STATE OF NORTH CAROLINA
DEPARTMENT OF TRANSPORTATION

Addendum No. 1

RE: Contract ID C202608

US-1 From the Lee County Line to the Wake County Line and
3 Sections of Secondary Roads

**TYPICAL SECTION NO.3**

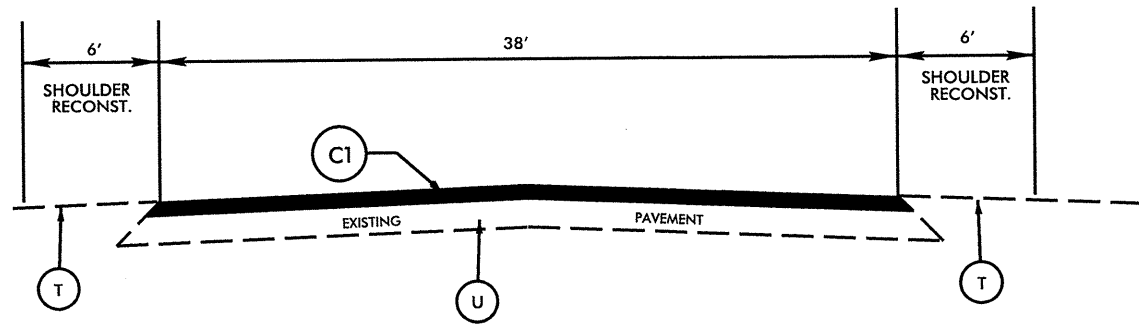
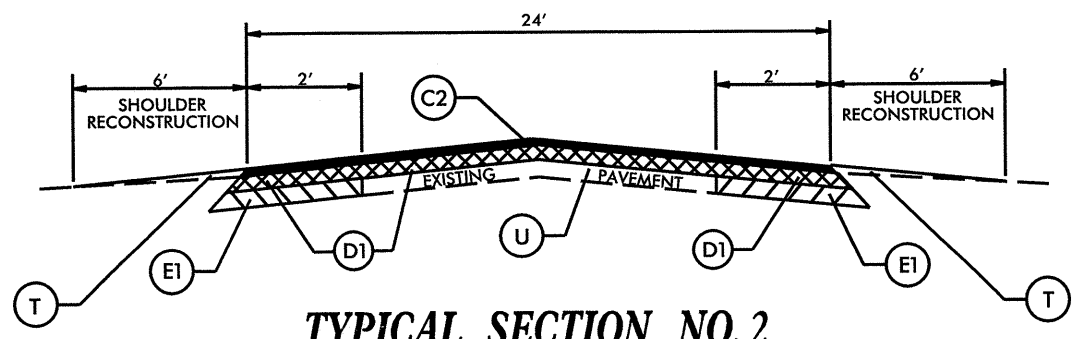
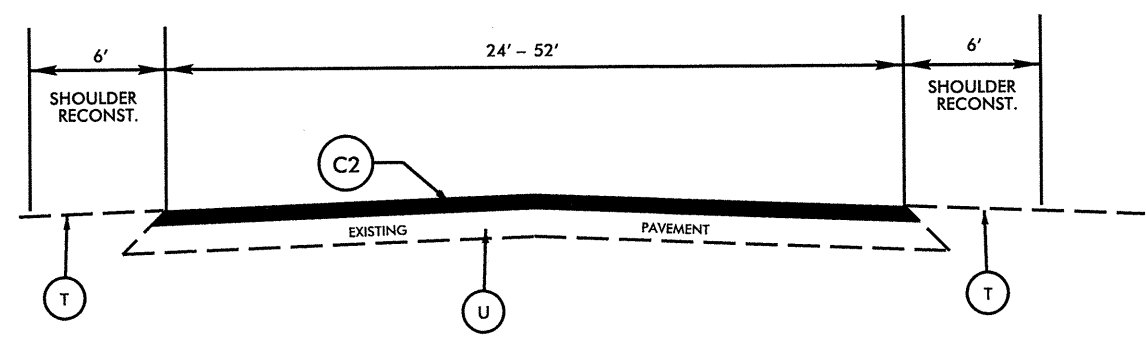
A note concerning resurfacing ramps was added to Sheet No. 3. Please void Sheet No. 3 in your sketch maps and staple revised Sheet No. 3 thereto.
